From: Scott Castle <[REDACTED]>
Sent: 20 September 2019 12:00
To: Carol Reynolds <[REDACTED]>
Cc: Anita Gardner <[REDACTED]>; [REDACTED]; Sue Shelley
<[REDACTED]>
Subject: RE: 22 Beach Road, Littlehampton.
Importance: High

From: Scott Castle <[REDACTED]>
Sent: 23 August 2019 16:19
To: Carol Reynolds <[REDACTED]>
Cc: Darren Godfrey <[REDACTED]>
Subject: 22 Beach Road, Littlehampton.
Importance: High

Figure 4. Internal Measurement Positions

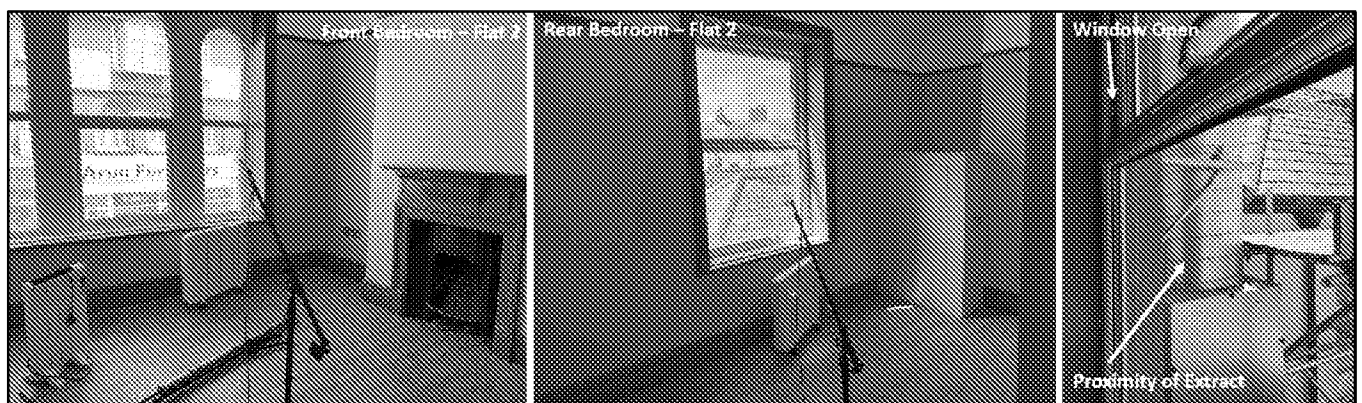
The reverberation times were measured in each of the locations where the surveys were undertaken. As noted from Table 3 in the report, the front bedroom in flat 2, was considerably higher in terms of reverberation than the smaller two bedrooms measured. As per Figure 4 of the report, the image displayed on the left hand side shows the laminated floor already laid.

When the bedroom is lived in and furnished with curtains, beds, pillows and duvets etc, the reverberation time will inevitably decrease and in this case a final reverberation time of 0.5s as was used in the calculations (This is what the Building Regulations state will be the average reverberation time for a furnished room). In this instance the correction used was 3dB as the empty surveyed rooms had an average reverberation time of 1s

Figure 7. Review of 1-hour periods inside Flat 1 bedroom

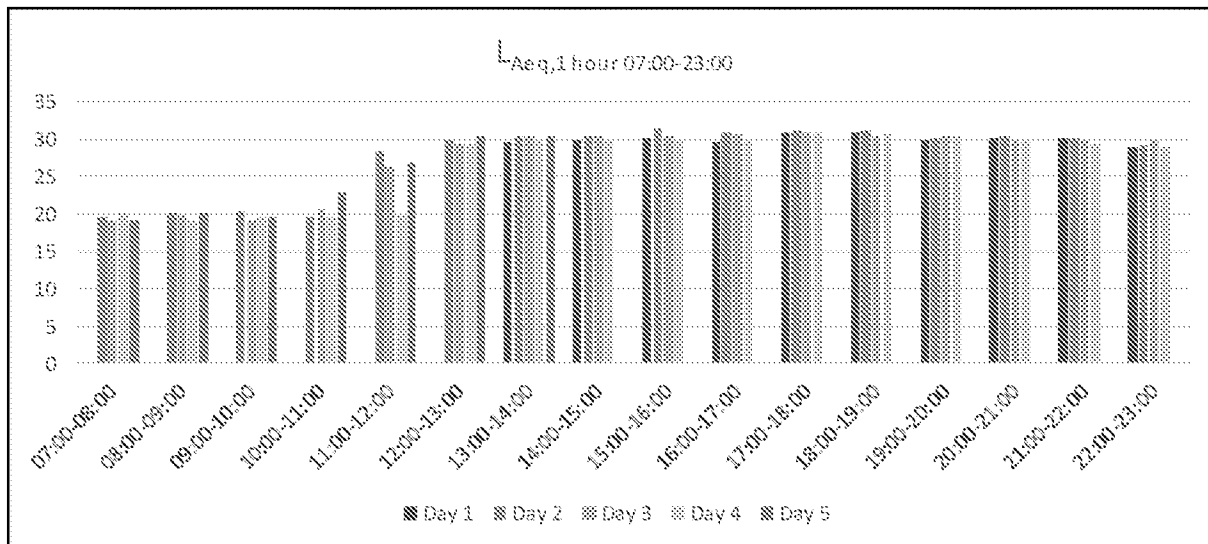
In respect of your report, 23rd August, page 3, paragraph 3 then to clarify, my comment related to **Figs 6 & 7** and **Flat 1** where daytime noise was found to be 28.8 with windows closed and therefore 39 to 44dB with reasonable adjustment for an open window.

Figures 6 and 7 in the report relate to Flat 1, however the references to 39 and 44dB relate to Flat 2, front bedroom, which is reported in Figure 10.

Figure 4. Location of Condensers serving Walk in Chiller

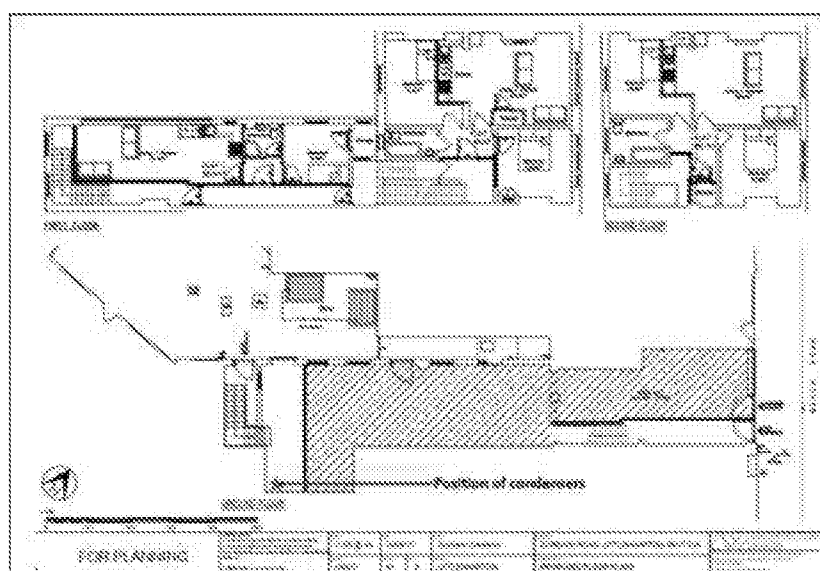
The condensers were previously located below the bedroom window but have since been relocated to inside the rear garage unit at the very rear of Flat 1, outside the demise of the flat.

The condensers are mounted on anti-vibration mounts on the ground floor. Both the garage and the pizza hut ceiling were soundproofed at the same time. The condenser positions inside the garage void are shown below.
